Reference No:	<b>2025/62/91342/W</b>
Site Address:	118, Sycamore Avenue, Golcar, Huddersfield, HD3 4SH
Description:	Erection of single storey front extension and rear dormer
Recommending Officer:	Joanna Rednall

## HOUSEHOLDER DELEGATED REPORT

<b>Application Number</b>	2025/91342
<b>Location</b>	118, Sycamore Avenue, Golcar, Huddersfield, HD3 4SH
<b>Proposal</b>	Erection of single storey front extension and rear dormer
<b>Publicity end date</b>	18 <sup>th</sup> July 2025
<b>Number of representations received</b>	None received
<b>Kirklees Local Plan Allocation/Designation</b>	Unallocated
<b>Extension to Time (EoT)</b>	<b>EoT Date: 27<sup>th</sup> August</b>
<b>Recommendation</b>	Conditional Full Permission

CLIENT	Mr Usman Iqbal				
ADDRESS	118 Sycamore Ave, Huddersfield, HD3 4SH				
PROJECT	Front Extension and Rear Dormer				
DRAWING	Existing and Prop Layout and Elevations				
DRAWN	UH	DATE	Feb 25	SCALE	1.100@A1
DWG No.	2516/01B				
STATUS	PLANNING

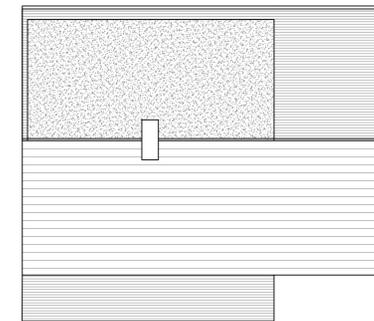
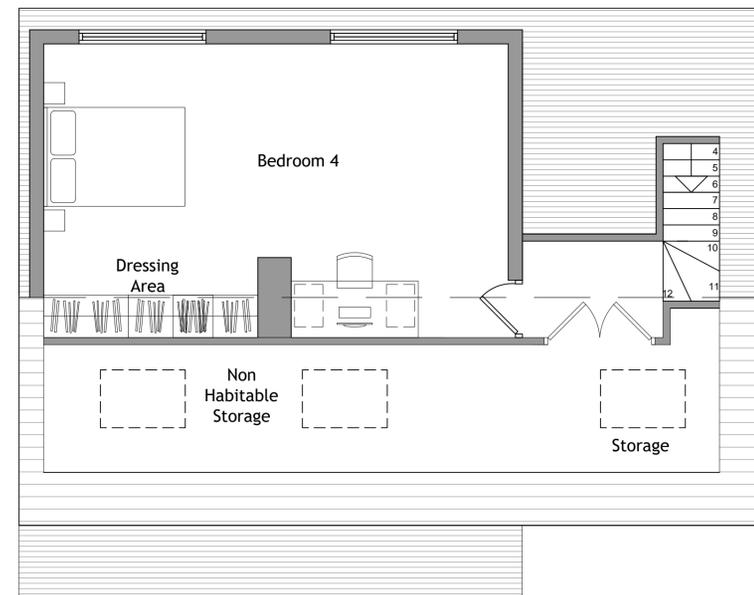
<b>YES / NO</b>	<b>SUMMARY</b>
Negotiations/Amendments during course of application	Yes	Officers raised concerns with the applicant’s agent regarding the rear dormer’s substantial size and scale, and its impact upon visual amenity. Following this, multiple discussions were held, and several sets of amended plans were submitted. The final revised plans, received on

The dormer is proposed to the rear roof slope, measuring ~7m in width, ~2.4m in height and ~3.5m in depth. The application form states the former would be clad in grey, similar colour to the roof tiles.

character of the property and surrounding area is minimized and would not be detrimental.
be designed in style and materials similar to the appearance of the existing house and roof	Acceptable for the reasons above.	
not dominate the roof or project above the ridge of the house		Whilst the dormer remains flush with the ridge line, officers consider the revised width, now comparable to that which could be constructed under permitted development rights. As such, the visual impact is now considered more acceptable. Given the extent to which a dormer to rear could be constructed upon the rear roof slope in any event of a similar design and scale it is considered this represents sufficient justification for the dormer the subject of this application. This conclusion is drawn having regard to previous roof additions and the volume they represent has a combined volume of 62m <sup>3</sup> . Given the potential to omit part of the scheme (front porch) and fact the proposal would see resultant roof slopes of 12m <sup>3</sup> volume above that achievable under permitted development rights (potentially less were the porch omitted)

- 78 Elmfield Avenue – neighbouring property to the rear. The proposed dormer would introduce additional openings at second-floor level facing the neighbouring property at No. 78. These windows would be approximately 8.8 metres from the side elevation of No. 78, which contains two first-floor windows. Given this separation distance, the development is not considered to result in a harmful overlooking impact, particularly as the dormer windows would be directed towards the side elevation of No. 78 rather than its private rear amenity space.

4. Notwithstanding the plans submitted the materials of construction of the walls of the rear dormer hereby approved shall be of a dark grey colour finish which shall be retained thereafter.

Officers sought amendments to reduce the size of the rear dormer to ensure the development would have an acceptable impact on visual amenity.
